From: Contact Centre (CRM) <contact@ribblevalley.gov.uk>
Sent: 24 May 2023 17:34
To: Planning
Subject: Planning Application Comments - 3/2023/0234 FS-Case-518770315

Planning Application Reference No.: 3/2023/0234

Address of Development: 95 Mellor Lane Mellor BB2 7EN

## AirForce® 1 Technical Specifications

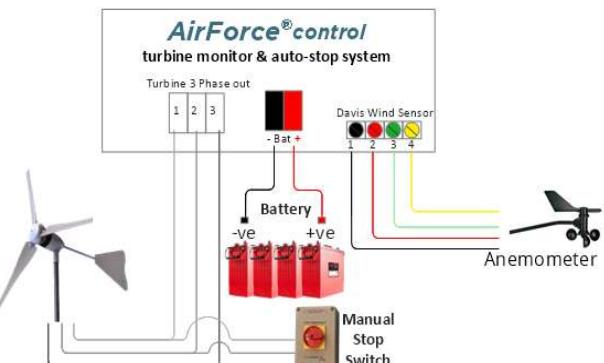
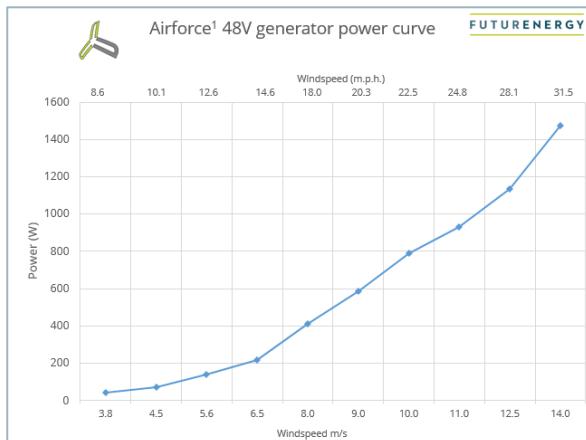
We are happy in principle with the proposed planning application, with the exception of the wind turbine. The specification sheet of the turbine suggests 35dB @ 5m/s (11.18mph) and 54dB @ 7m/s (or 15.66mph). However, with Mellor being high on a ridge, the wind here frequency can hold steady at around 20mph. If we extrapolate the noise figures, then we could be experiencing a noise level far in excess of 54dB, possibly closer to 70dB. This is the noise level of a typical washing machine, but this noise will be carried on the wind, potentially all through the day and night. As such, we don't believe such a wind turbine is suitable where there are other residential properties in close vicinity. Furthermore, the application details suggest a turbine height of 8 metres and when combined with the numerous guide ropes required, there will be a significant visual impact, which again we believe is unacceptable and also not in keeping with the area.
